Item No. **Report of the Head of Planning, Transportation and Regeneration**

Address 27 WOODSTOCK DRIVE ICKENHAM MIDDLESEX

Development: Variation of condition Nos. 2 (Approved Plans) and 4 (Windows) of planning application Ref: 61790/APP/2018/1659 dated 24/08/2018 to increase the width of the two storey side extension, amendments to the approved plans and openings and include 2 x single storey front extensions (Part two storey, part single storey side/rear extension and canopy to front involving demolition of existing garages).

LBH Ref Nos: **61790/APP/2020/3684**

18 PROPOSED 3D VIEW FROM WOODSTOCK DRIVE

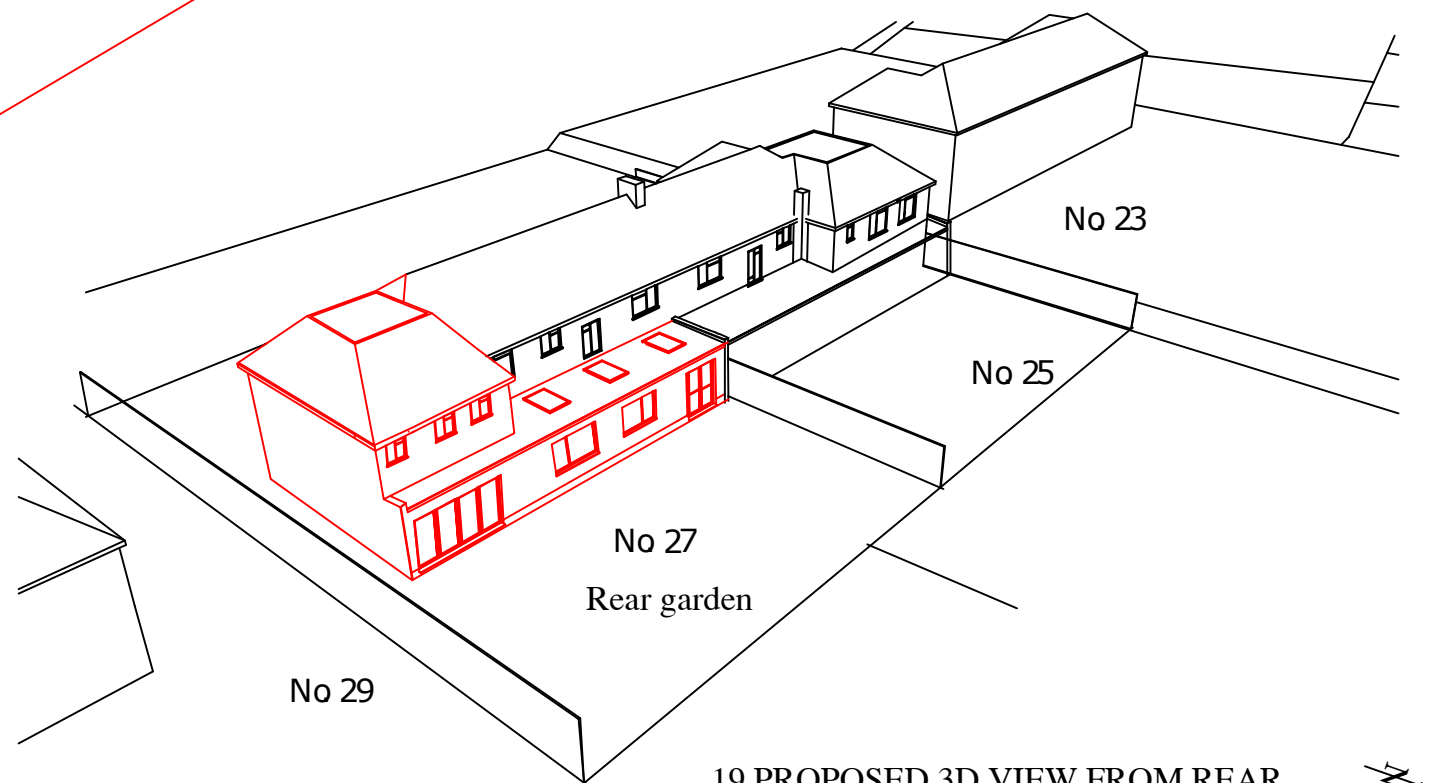
The proposed two storey side extension, by virtue of its size, scale, bulk, width and design would fail to appear as a subordinate addition and would thus fail to harmonise with the architectural composition of the original semi-detached dwelling, would be

The proposed side and front extensions by reason of their siting in a visually prominent location and their projection forward of the main front elevation and design, would represents disproportionate and incongruous additions that fail to harmonise with the architectural composition of the original dwelling and would be detrimental to the visual amenities of the street scene and the surrounding area. Therefore the proposal would be contrary to Policy BE1 of the Hillingdon Local Plan: Part One - Strategic Policies (November 2012) and Policies DMHB 11, DMHB 12 and DMHD 1 of the Hillingdon Local Plan: Part Two - Development Management Policies (2020).

13 PROPOSED FRONT ELEVATION

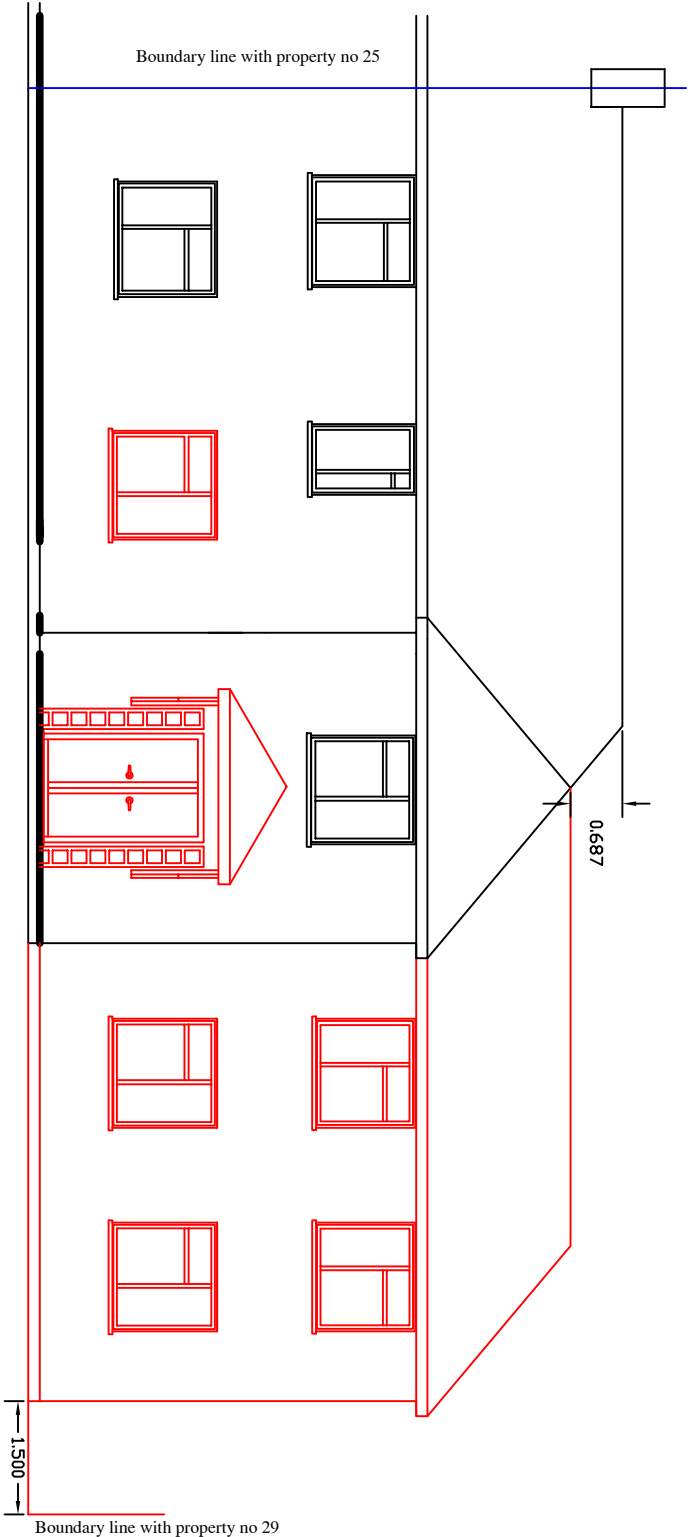
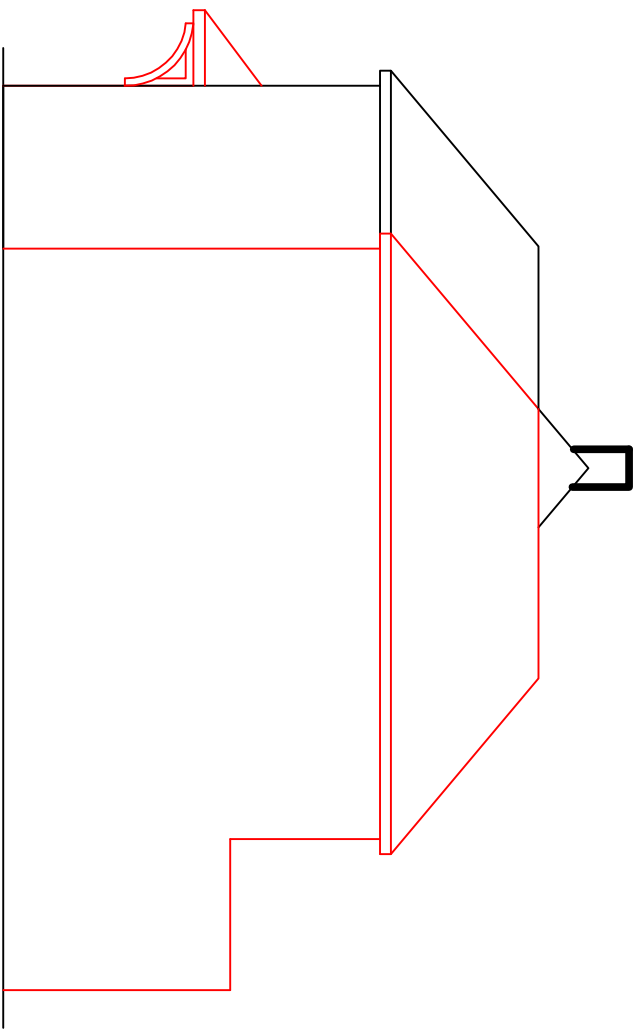
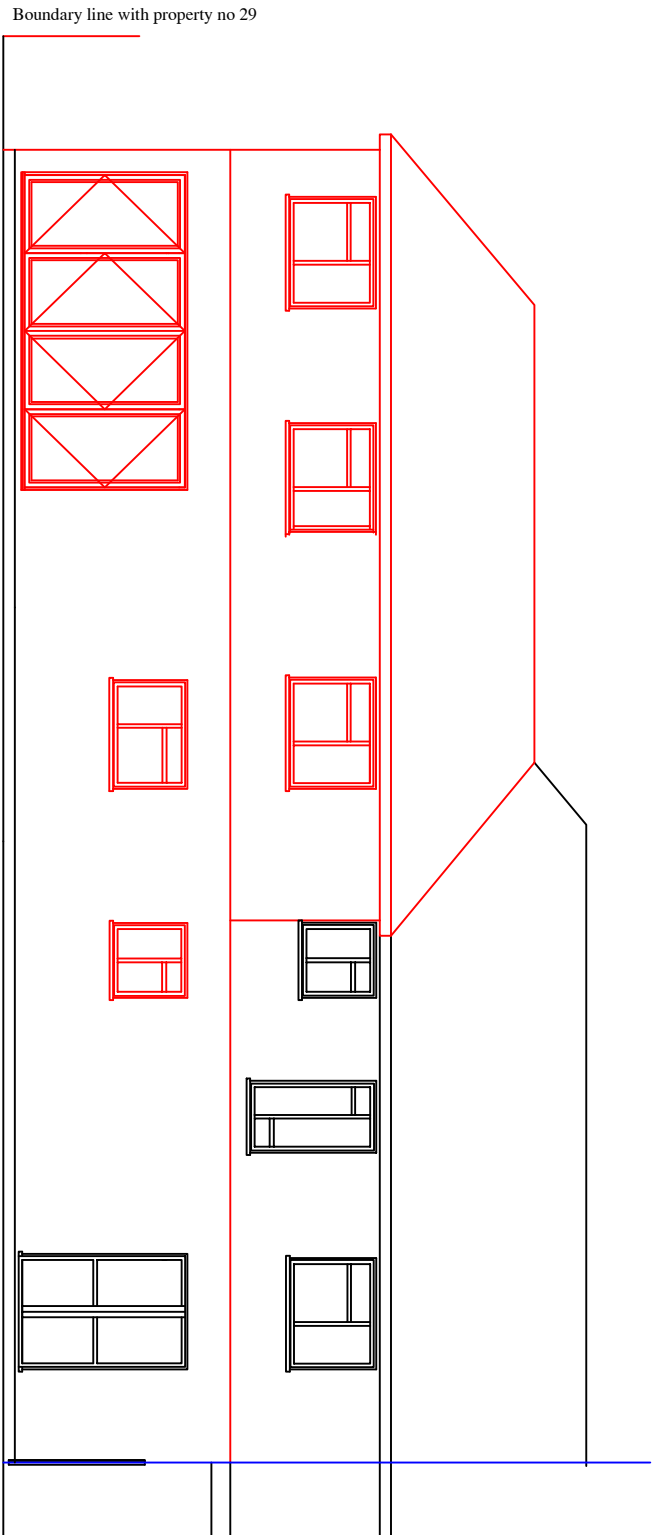
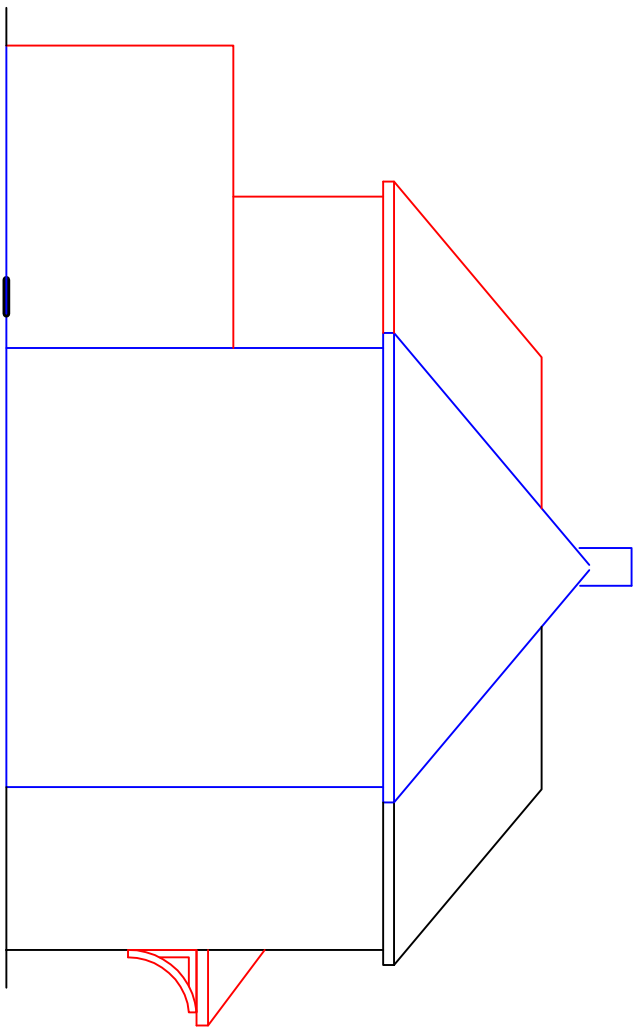
The two storey side extension would have a width of 7m (increased by 1m from the approved scheme) and wrap around to the rear of the property extending 2m deep. The two storey side extension is set in 0.5m from the side boundary. The extension would be characterised with a centrally hipped roof with a crown roof which would be of a similar pitch as the roof on the main dwelling and would be set down below the ridge of the main roof by 0.63m. Materials would match the existing house. The single storey side/rear extension would have a flat roof measuring 4m deep and 3m high. The front canopy would have a pitched roof 3.4m high and 2.45m wide. The width of the two storey side extension would be unacceptable, by reason of it closing the gap with the side boundary and unbalancing the pair of semi's. The two storey side extension would be considerably in excess of half the width of the original dwelling (original dwelling width 11.5m) and this width, allied to the front extensions results in a two storey extension which, by virtue of its size, scale, bulk, width and design would fail to appear as a subordinate addition and would thus fail to harmonise with the architectural composition of the original semi-detached dwelling, would be detrimental to the character, appearance and symmetry of the pair of semi-detached houses of which it forms a part and to the visual amenities of the street scene and the surrounding area. Therefore the proposal would be contrary to Policy BE1 of the Hillingdon Local Plan: Part One - Strategic Policies (November 2012)

With regards to front extensions, the Council will not normally accept front extensions and canopies including extensions linked to garages and porches as these not only affect the character and building itself but also the street scene. The proposal shows two single storey front extensions, measuring 2.3m deep, 7m and 3.9m wide and 3.65m high with a lean-to roof. The front extensions, by reason of their width, depth, position in a visually prominent location, projection forward of the main front elevation and design, would represent disproportionate and incongruous additions that fail to harmonise with the architectural composition of the original dwelling and would be detrimental to the visual amenities of the street scene and the surrounding area. Accordingly, it is considered that the proposal would not comply with the objectives of Policies DMHB 11 and DMHD 1.
